City of Albuquerque

REF: DRAINAGE PLAN FOR LOT 117, MAYO ROSS SUBDIVISION, 308 MOUNTAIN ROAD NE
(J14-D32)

These are my comments on the above drainage plan:

GRADING & DRAINAGE PLAN

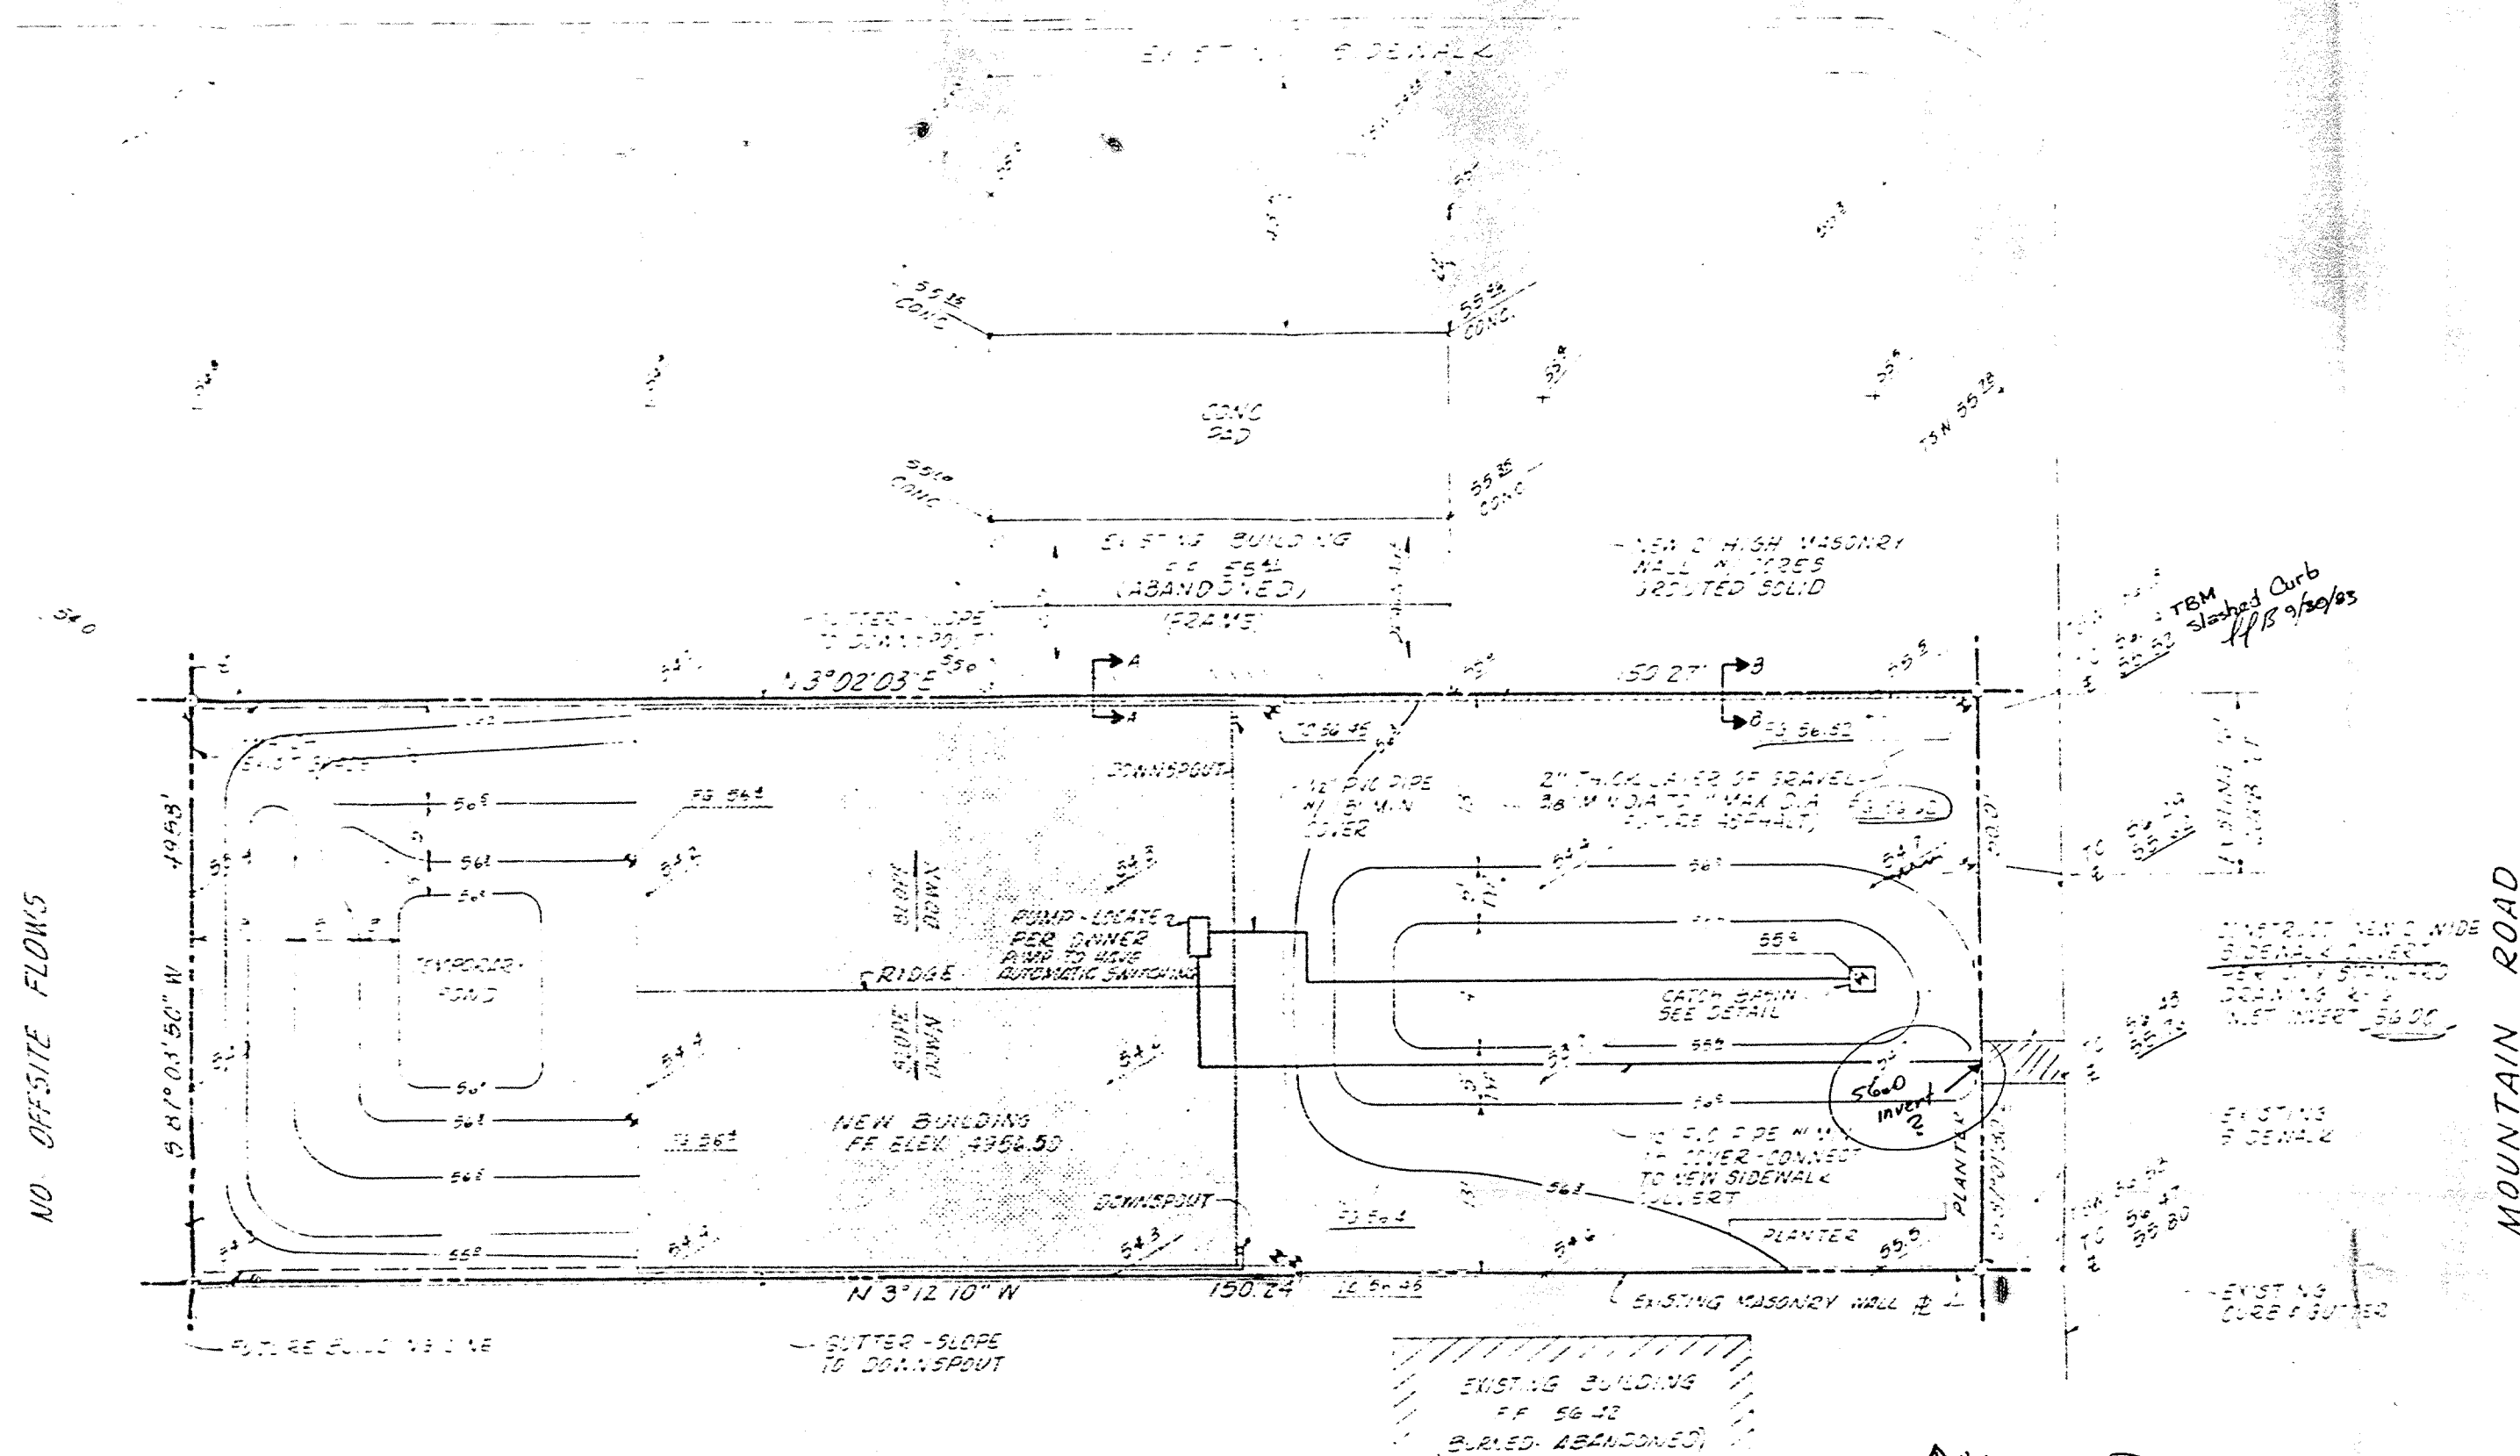
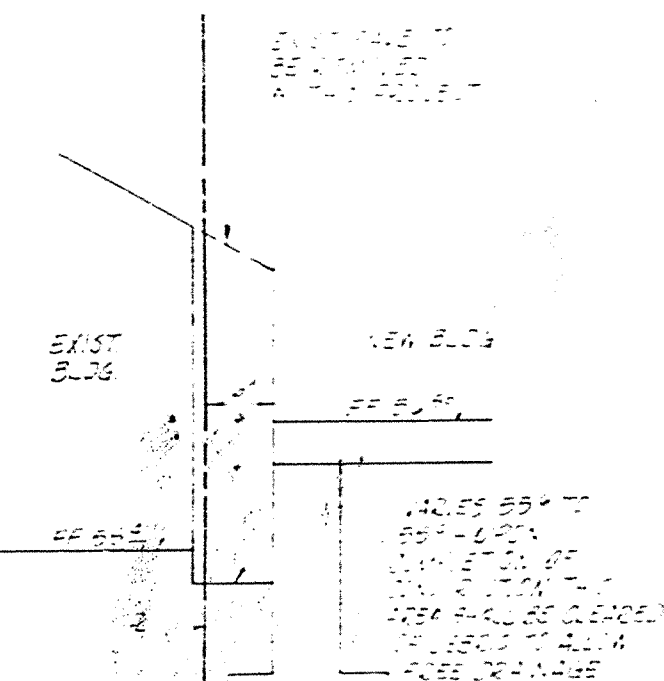
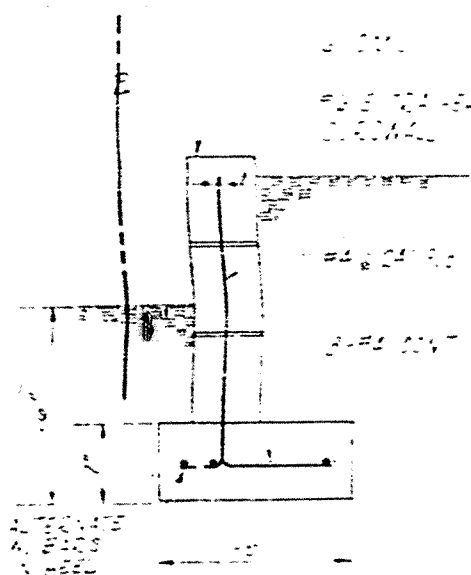
1. Checklist (per DPM, Sec 2, 7, P, 106-109) items include but are not necessarily limited to the following:
 - a. Discuss offsite flows and show offsite grades, Enough detail must be shown to substantiate that offsite flows are not blocked and that on site water stays on site or exits to public Right-of-Way.

- b. Emergency spillway calculations,
 - c. Temporary Bench Mark must be set on site and referenced on the drawing.
2. All on site ponds must have positive out fall to drain within 24 hours and must provide an emergency spillway to prevent flooding of on site or offsite structures.

3. The time of concentration on sites this small is considered to be 10 min which makes the intensity 4.65 in/hr. This storm should be routed through the pond using the runoff hydrograph shown in DPM Plate 22,2 E-1, (p. 18).
